File Number: SSD 6840 MOD 2
Our Ref: R/2014/44/C

RE: SSD 6840 MOD 2 – Modification Application – St Vincent's Private Hospital Sydney

1 VICTORIA STREET ELEVATION
1:200

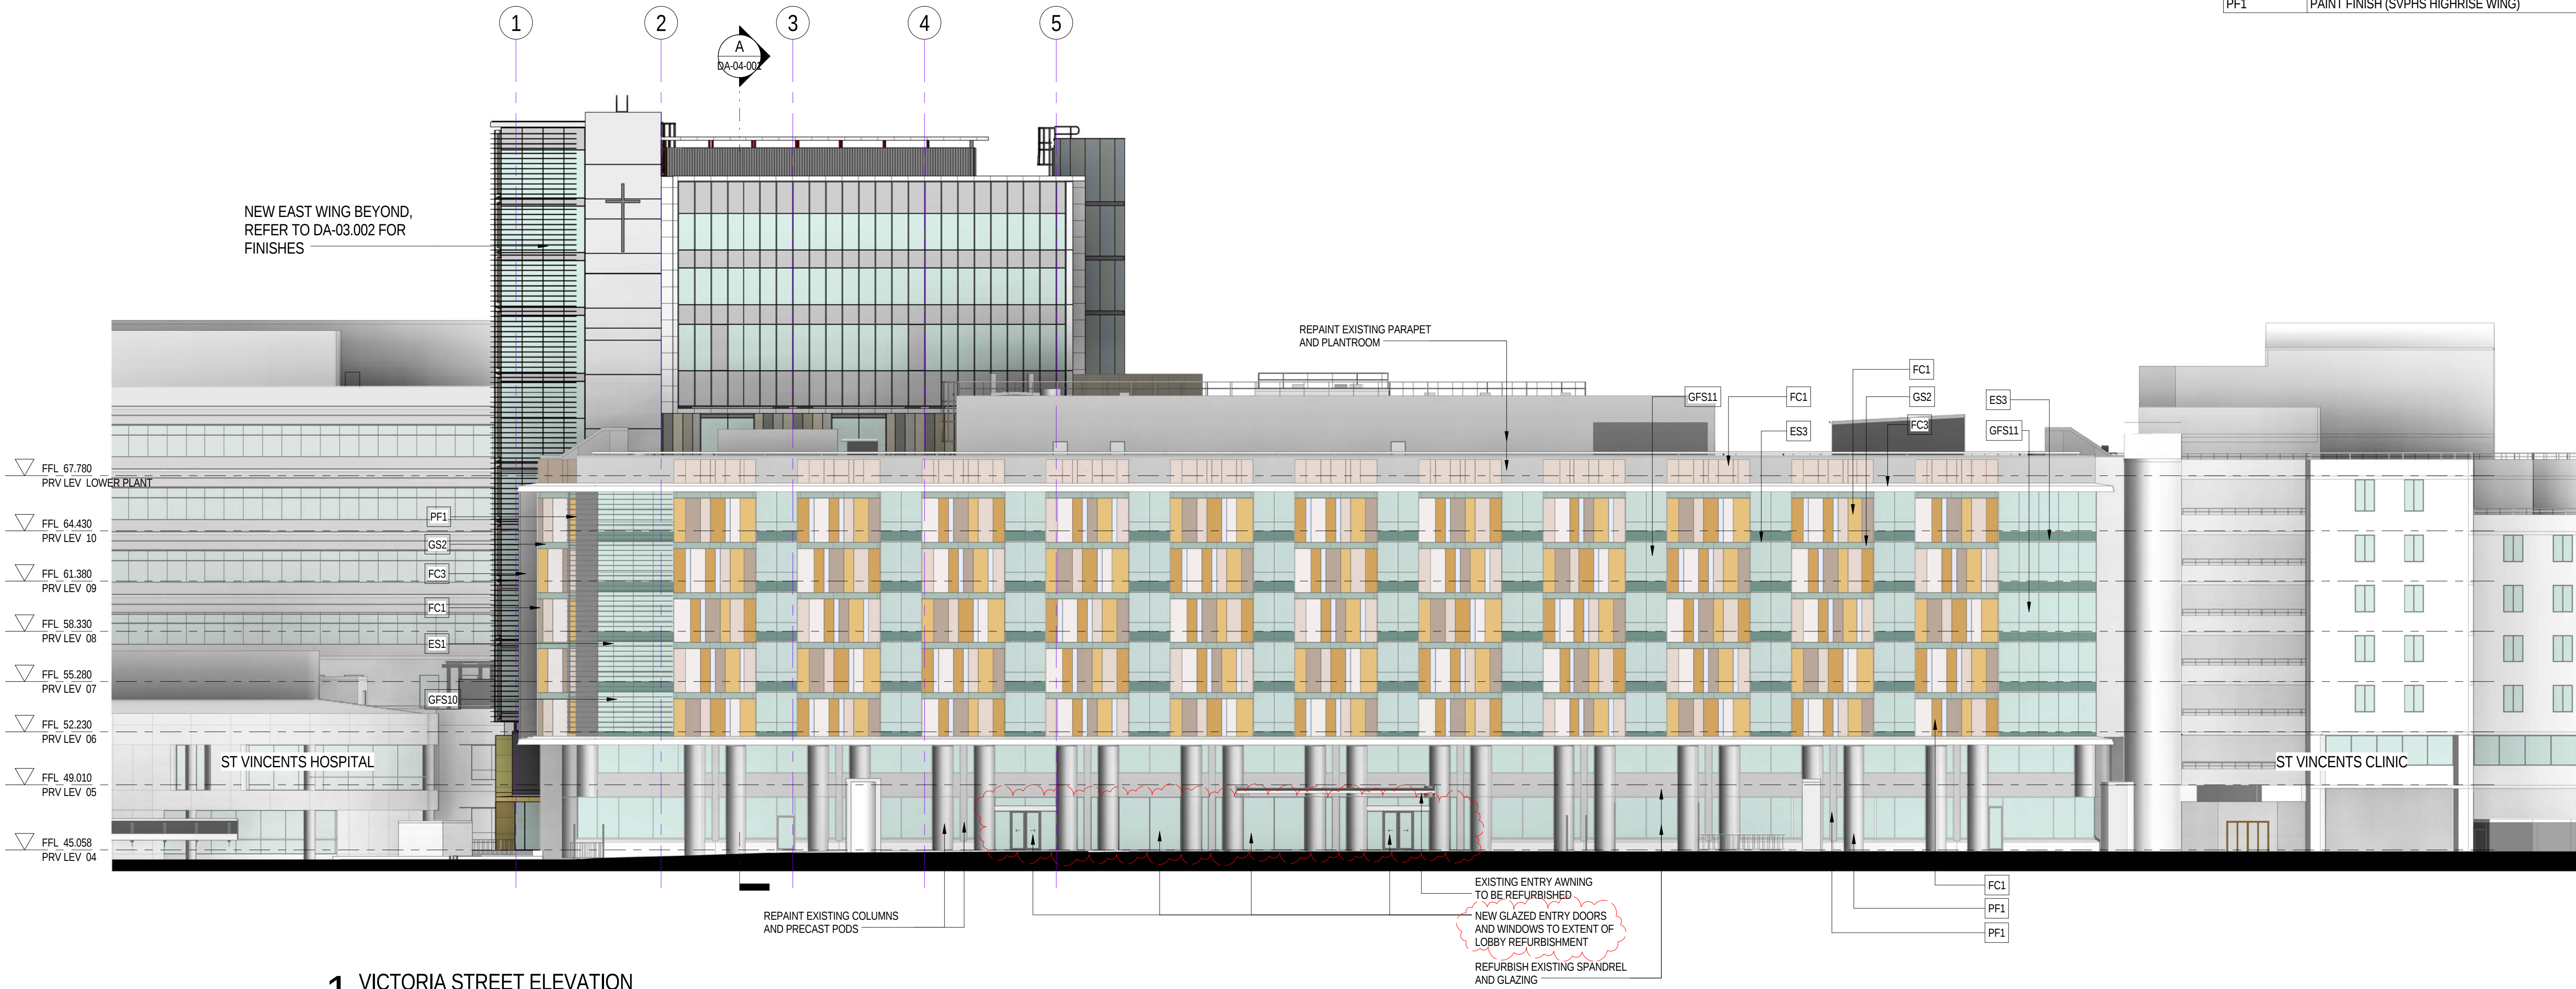
Insufficient information has been provided in order for the City to properly comment on the proposed modification. In this regard, elevational drawings should be submitted to the Department illustrating the extent of proposed amendments to Victoria Street. Once received, it is requested that the plans are made available to the City to assess the replacement of part of the existing Victoria Street facade.
